ADMINISTRATIVE AMENDMENT

A1 SITE PLAN
1" = 30'-0"

PROJECT NUMBER: PR-2021-005473
Application Number: SI-2021-00709

LADERA BUSINESS PARK UNIT 1 - CACTUS PATCH PLAZA

D1 BLDG C - ELEVATION EAST  
1/8" = 1'-0"

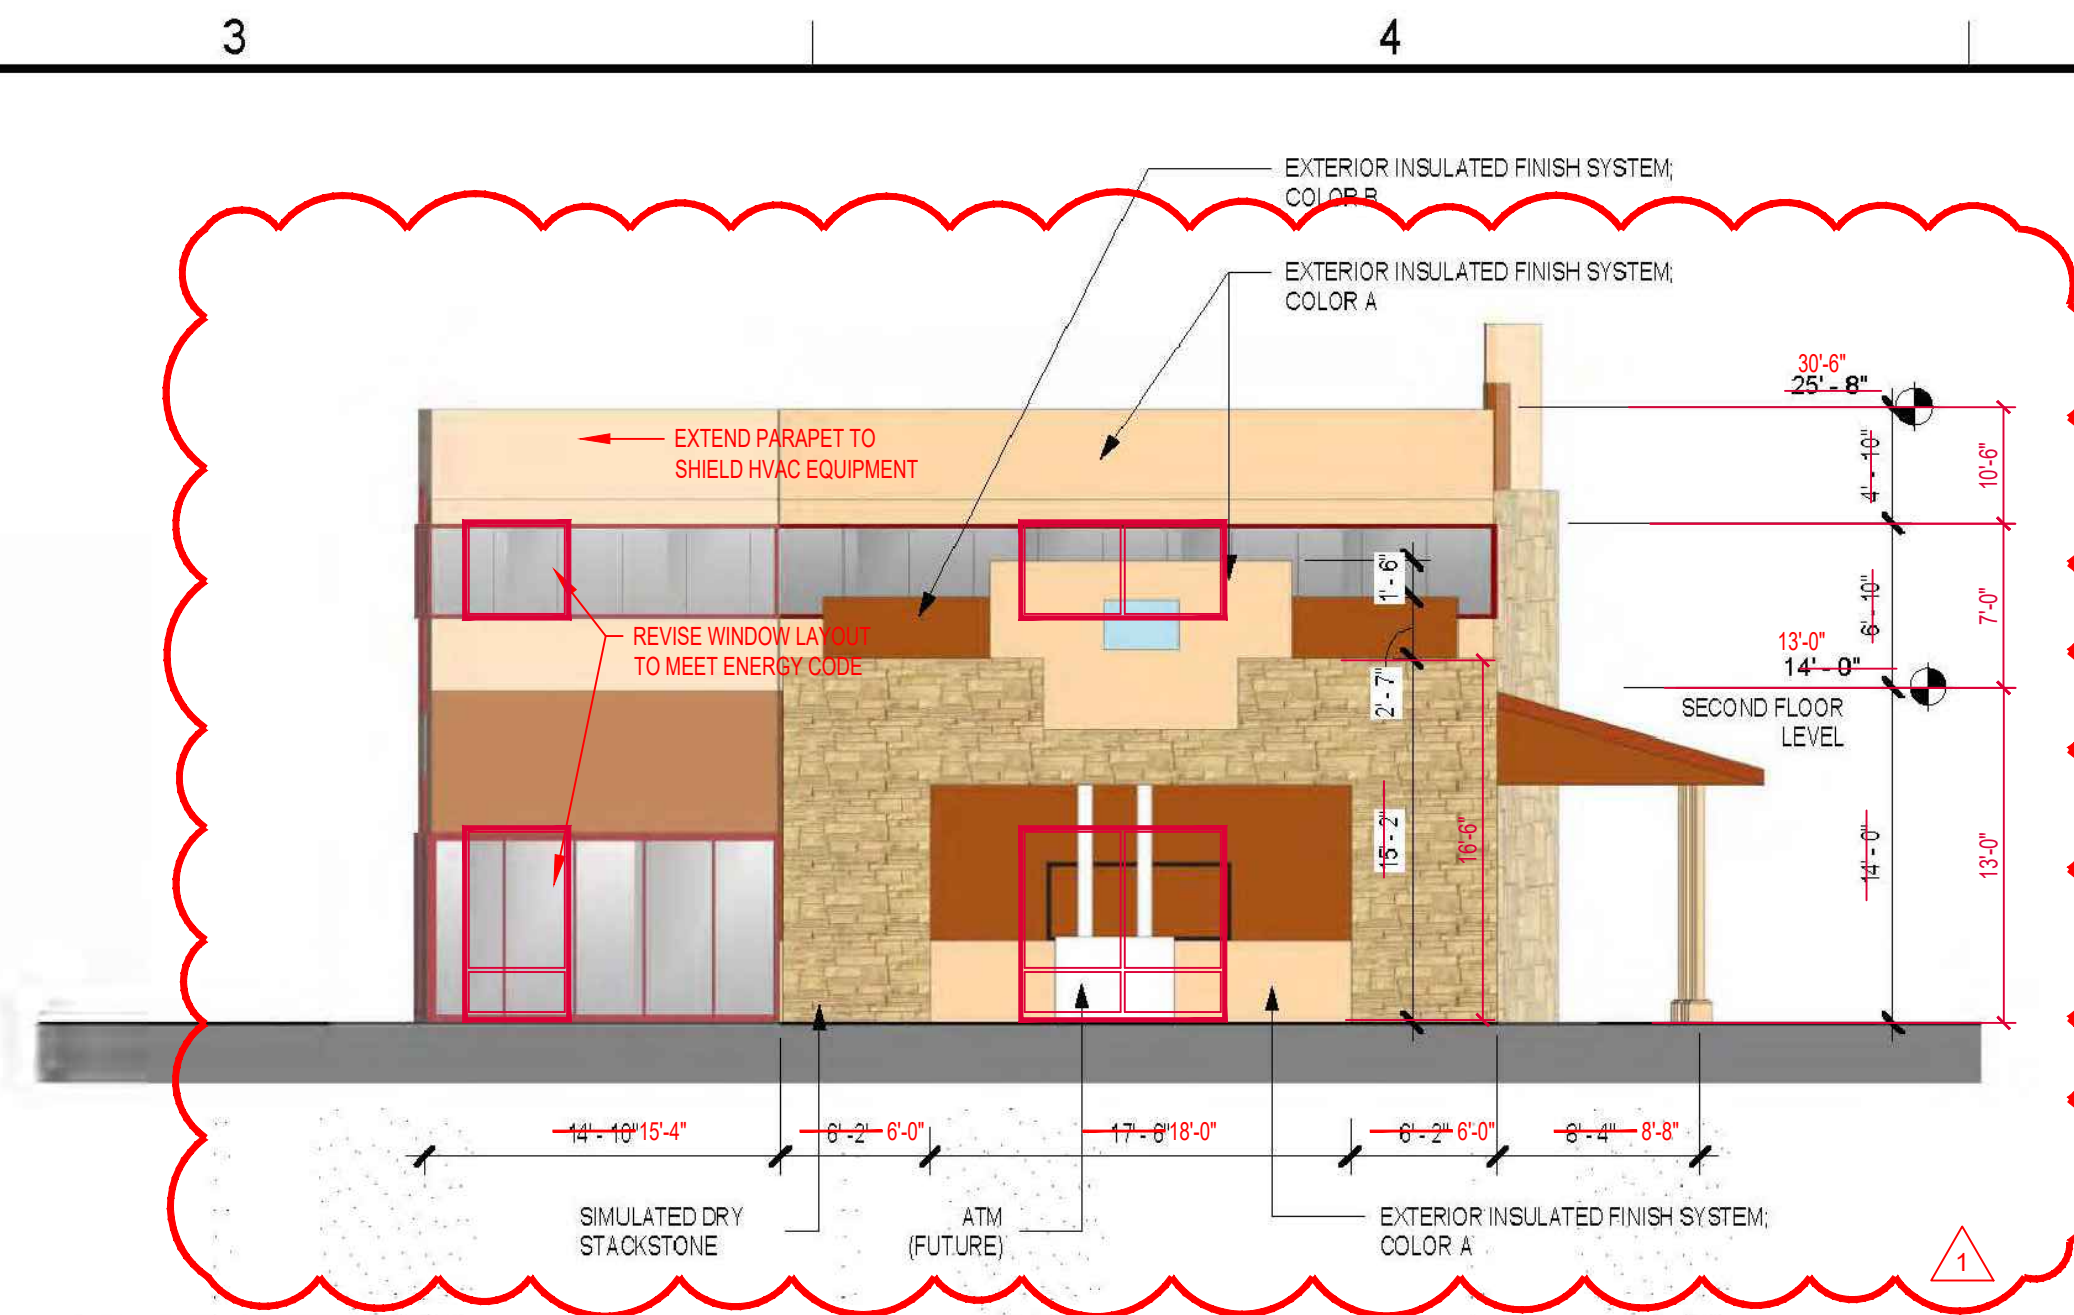
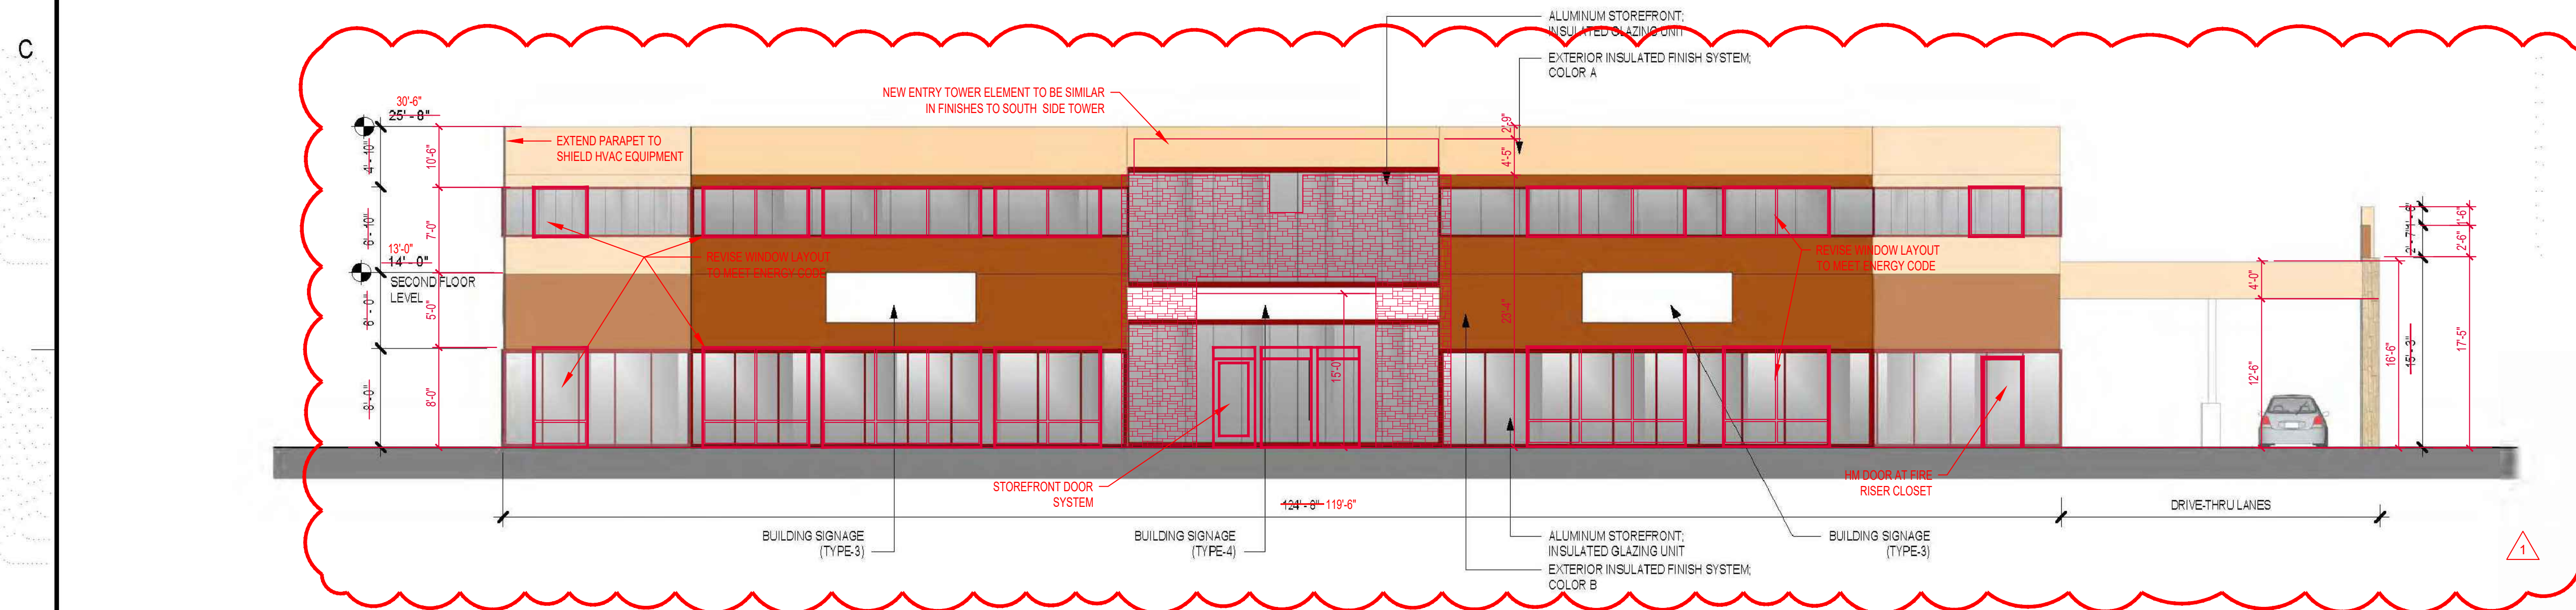
- Add 3x10' opening in parapet for access for HVAC installation to avoid overhead power lines.
 - Building C Elevations:
 - Increase entry tower building height from 29'-3" to 32'-0".

- Increase building parapet height to 30'-6" to provide HVAC screening.
 - Revise window layouts to meet energy code requirements.
 - add entry element to north side of the building facing the courtyard and building B.
